| Application Ref:            | 3/2026/0341 |              |          |  <div>Ribble Valley<br/>Borough Council</div> <hr/> <a href="http://www.ribblevalley.gov.uk">www.ribblevalley.gov.uk</a> |
| DELEGATED ITEM FILE REPORT: |             |              |          | APPROVAL                                                                                                                                                                                                   |

| <b>Development Description:</b> | Proposed erection of three single storey leisure facility buildings within the hotel grounds. |
| <b>Site Address/Location:</b>   | Foxfields Country Hotel, Whalley Road, Billington, BB7 9HY.                                   |

Drawing Title
Proposed Foul Water & Surface Water Plan

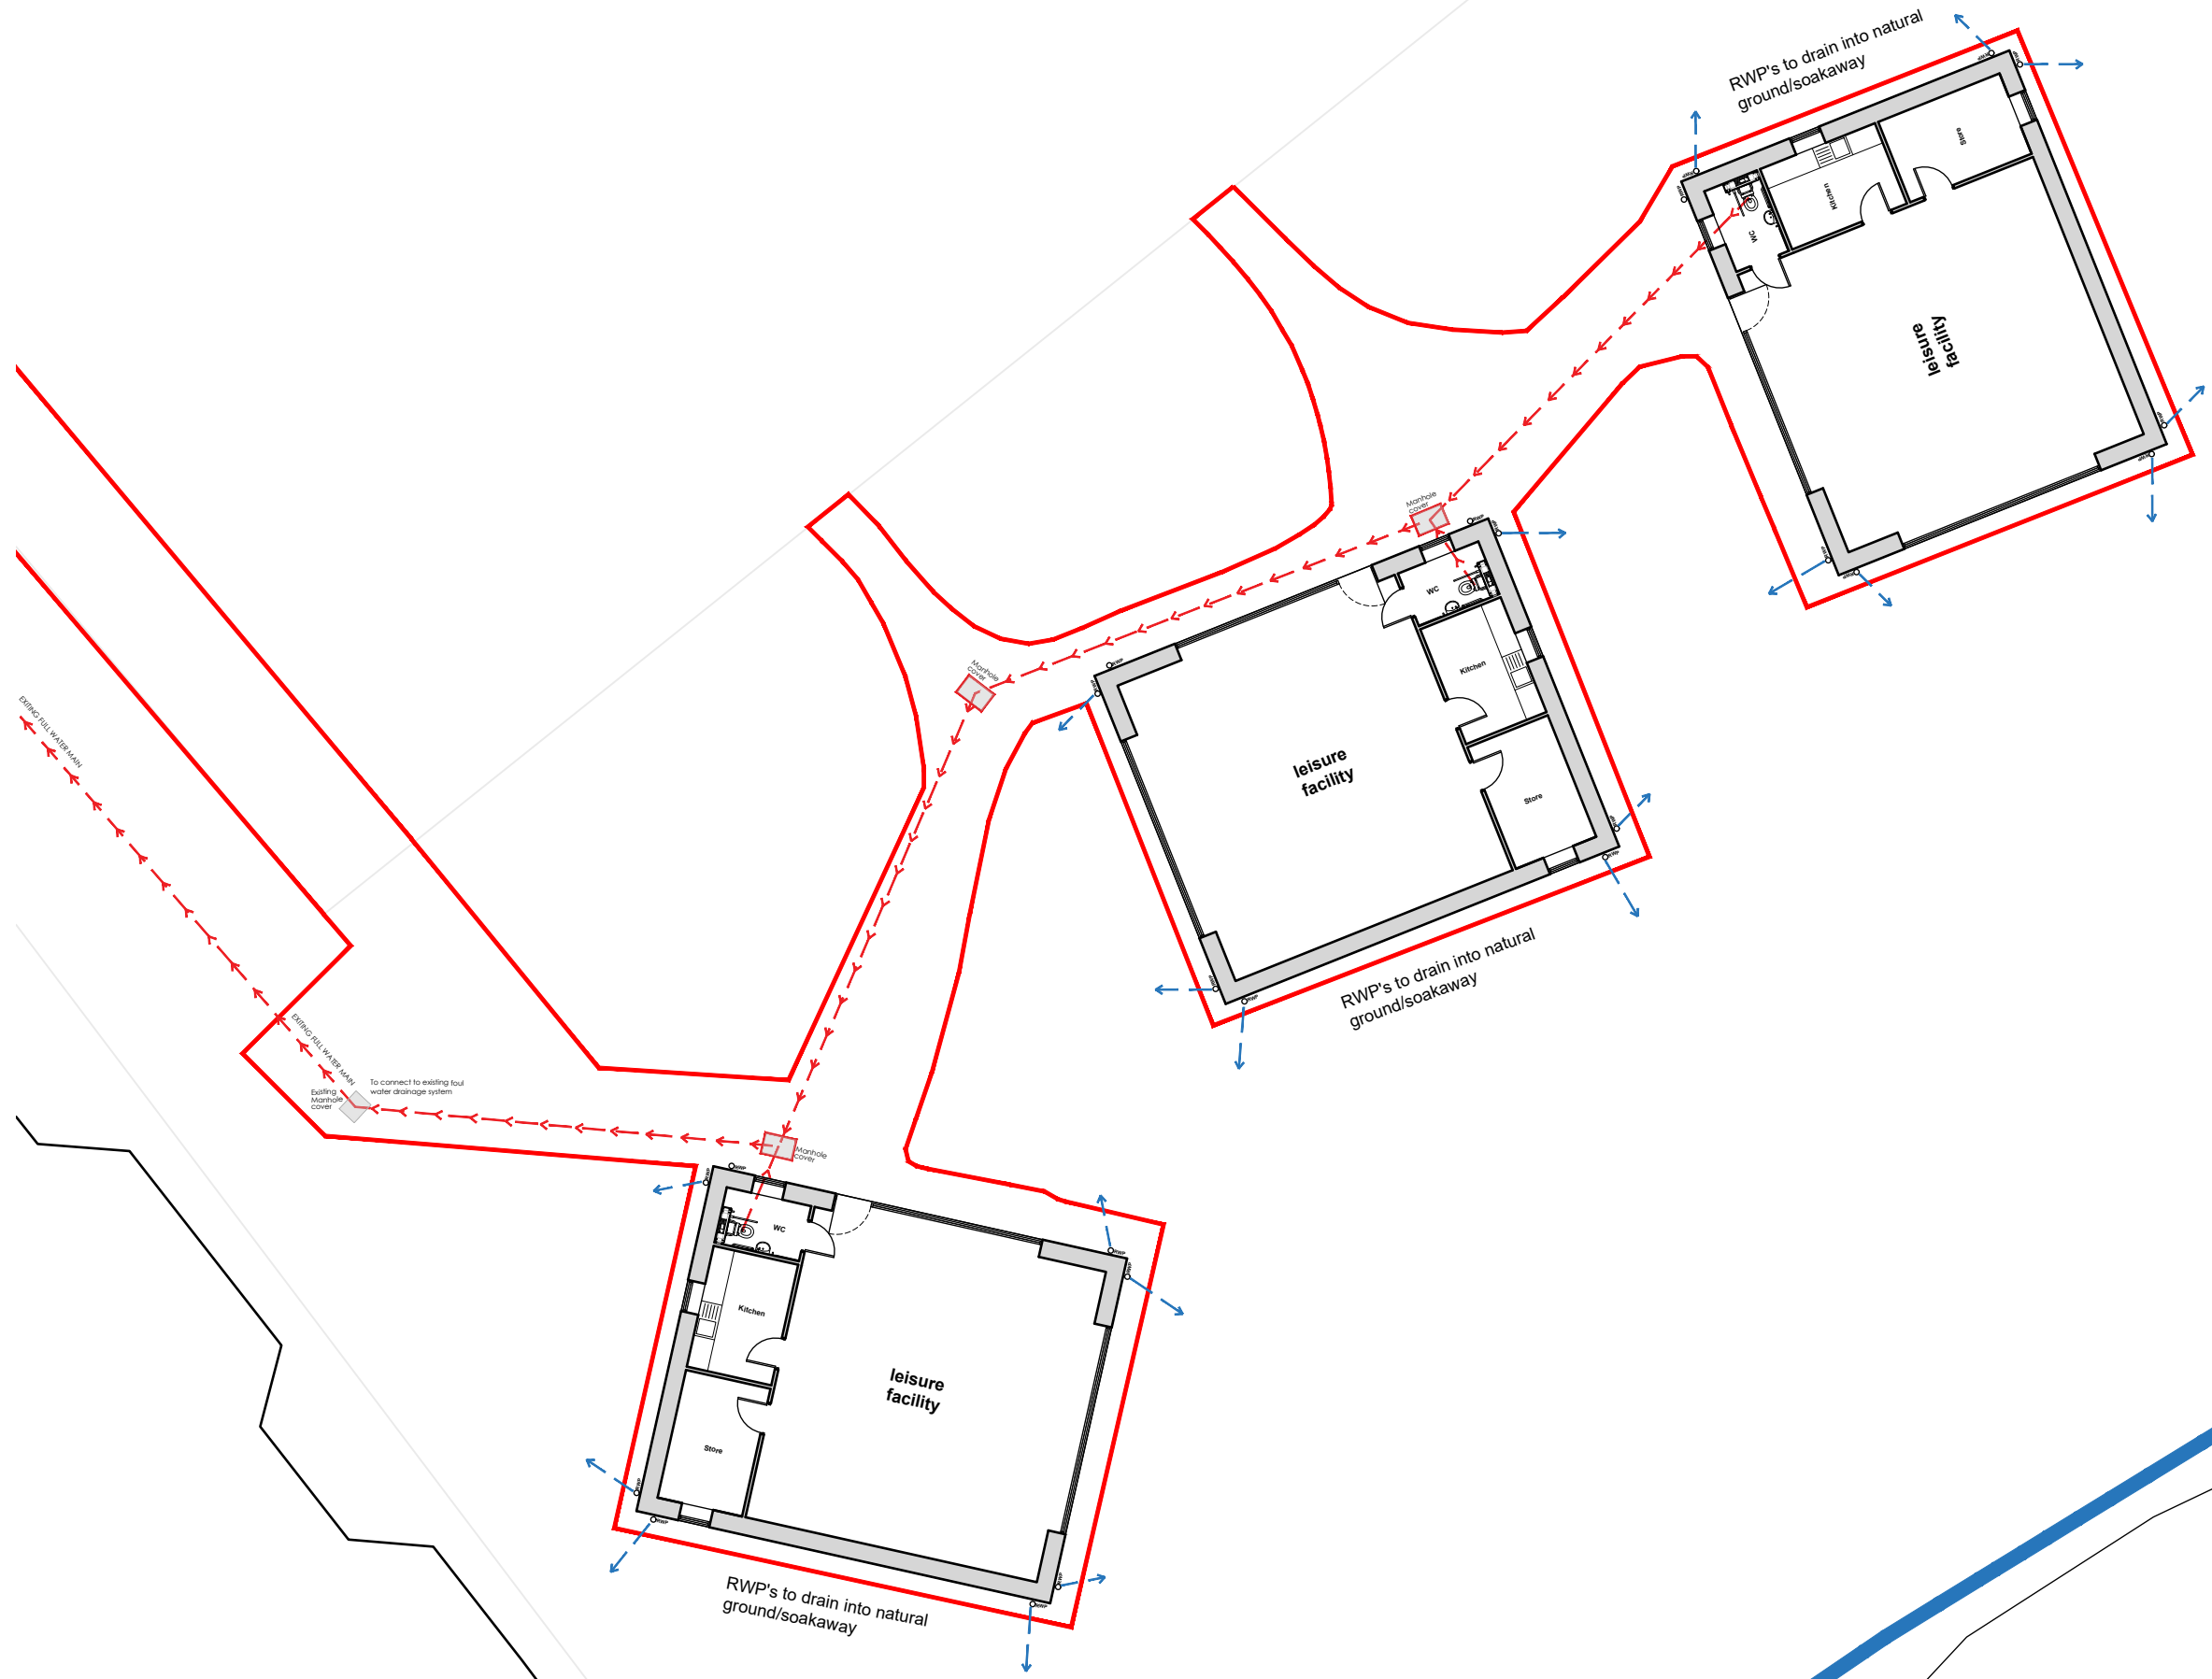
Concerns have been raised in a third-party representation regarding the potential impact of the development on surface water drainage. However, the proposed development is not located within an area identified as being at risk of surface water flooding.

The application is supported by a drainage strategy which demonstrates that surface water would be disposed of via infiltration to the ground and/or soakaways, while foul water would be directed to the existing foul drainage system. The proposed drainage arrangements are considered acceptable in principle and can be secured through the imposition of an appropriately worded planning condition.

Drawing Title
Proposed Site Plan

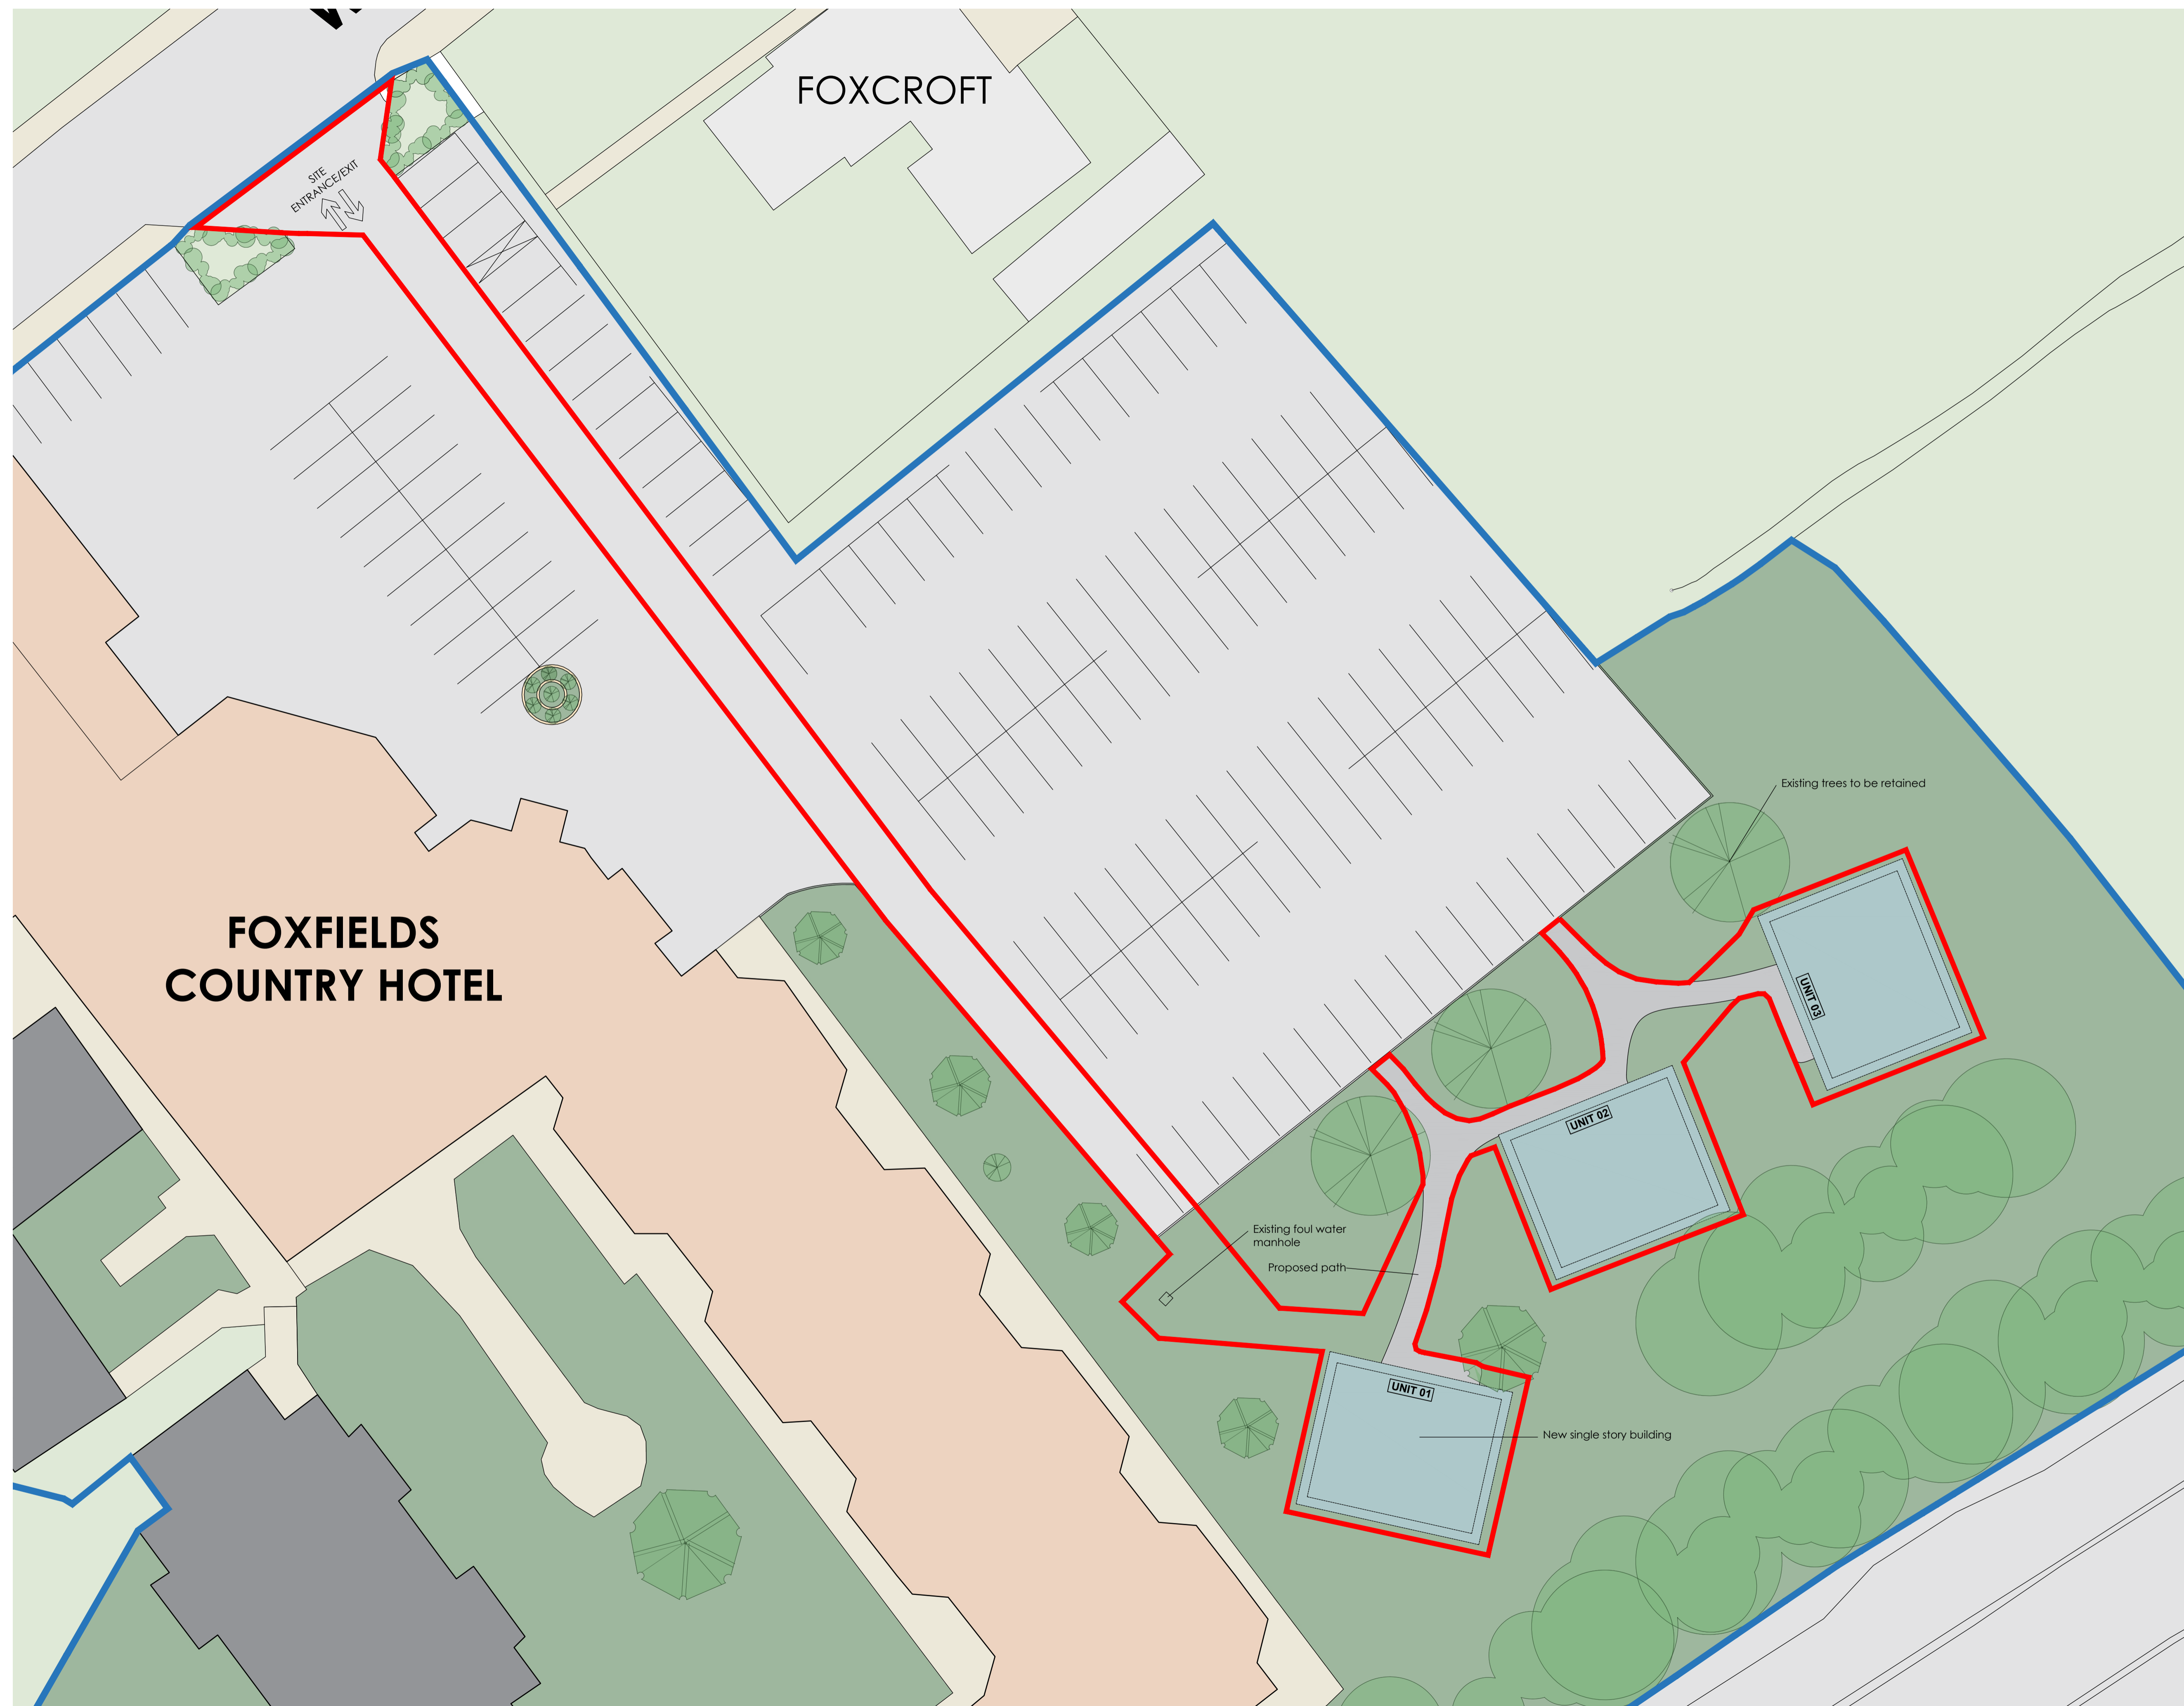
The LHA also recommended that the proposed footpath surrounding the new buildings should connect directly to the existing stone-flagged pedestrian route around the main hotel building, rather than through the car park. This would provide a dedicated and segregated pedestrian route, improve pedestrian safety and reduce the potential for conflict with vehicles manoeuvring within the car park. These comments were relayed to the applicant, who has subsequently submitted amended plans incorporating this change.
